Barbara Barhydt - Bayside Bowl

June 9, 2011

Project Name: Outdoor Patio, Bowl Portland **Project ID:** 2011-204
Address: 58 Alder Street

FD.1
Level 1 Site
Plan Alteration

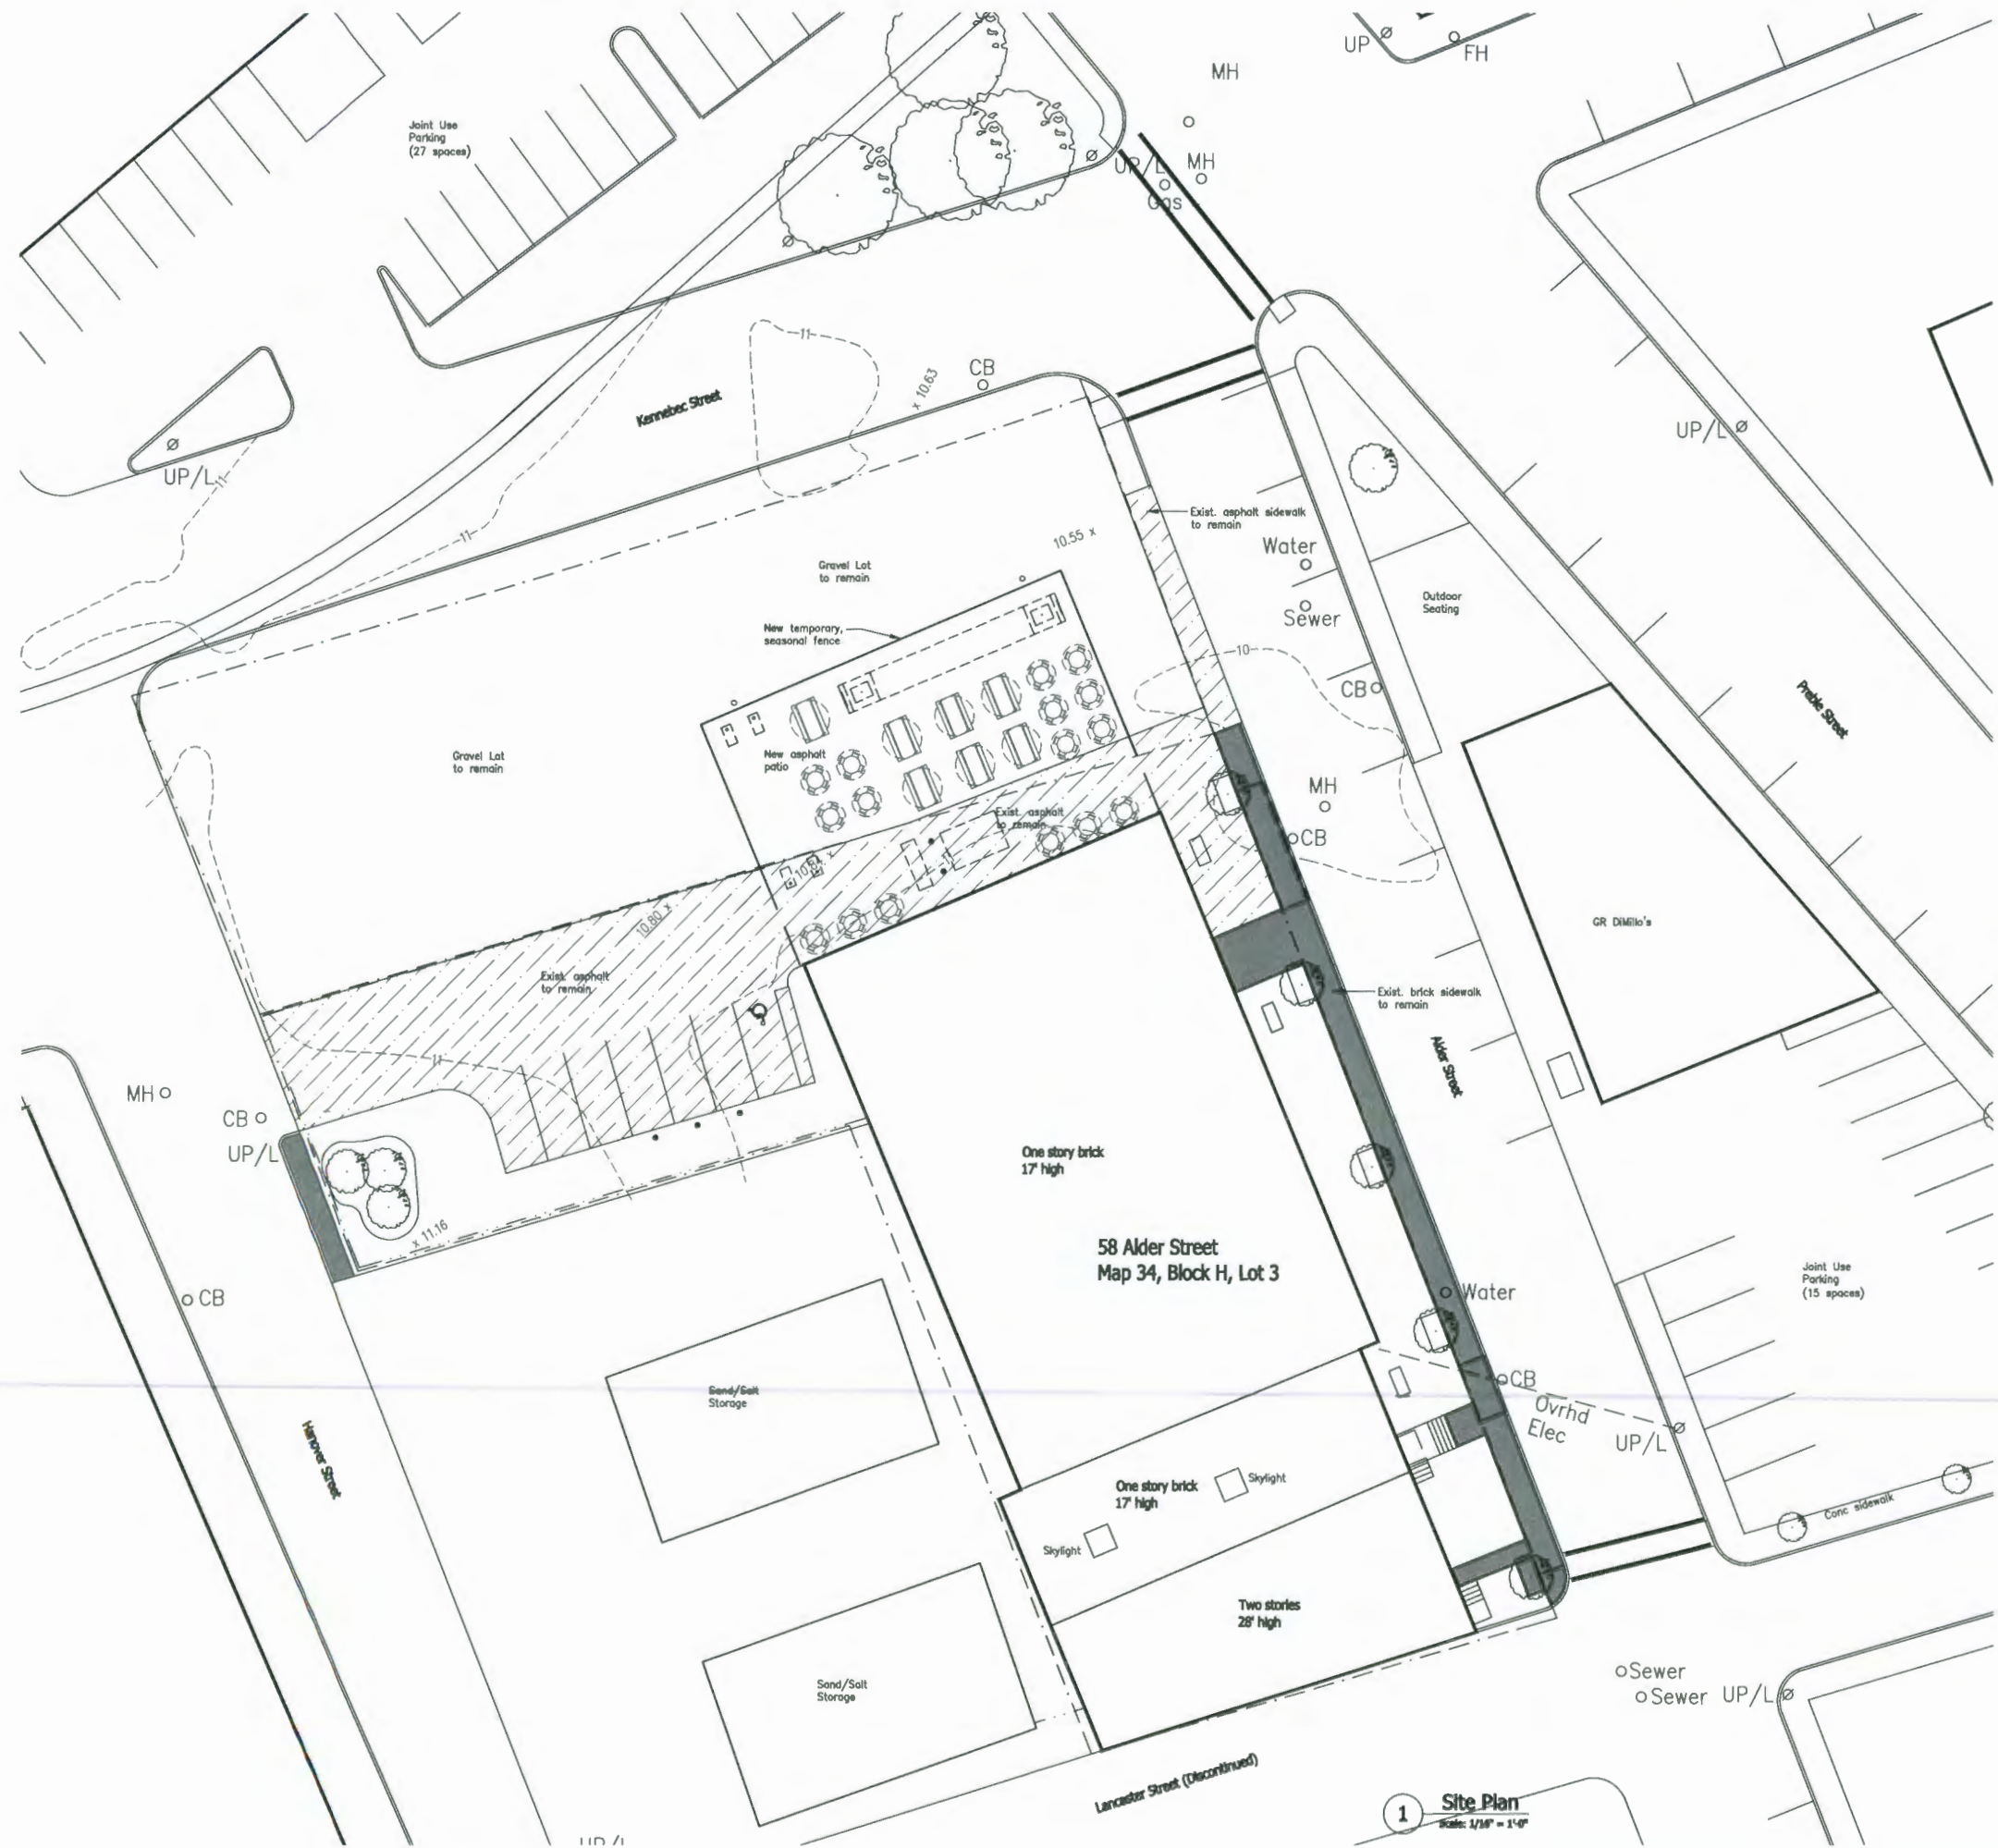
We have reviewed the plans prepared by David Matero of DayMatero Studio. You propose to pave approximately 2,757 sq ft on the site for use as an outdoor seating space and outdoor game area (such as horseshoes and cornhole toss). The total patio area will measure 4,140 sq ft. You also propose to place a metal interlocking fence around the perimeter which will be removed when the patio closes for the season.

2. Fencing and Landscaping. Given the seasonal nature of the project, the proposed removable fencing is permitted, just as one would use temporary barriers at a sidewalk café to provide separation between pedestrians and the patrons. If the applicant decides in the future to install permanent fencing, the City's technical specifications will apply.

Landscaping, including trees, will be required to be planted as part of the permanent site work. In the meantime, at a minimum, planters with flowers and/or plants are expected to be included as part of the project.
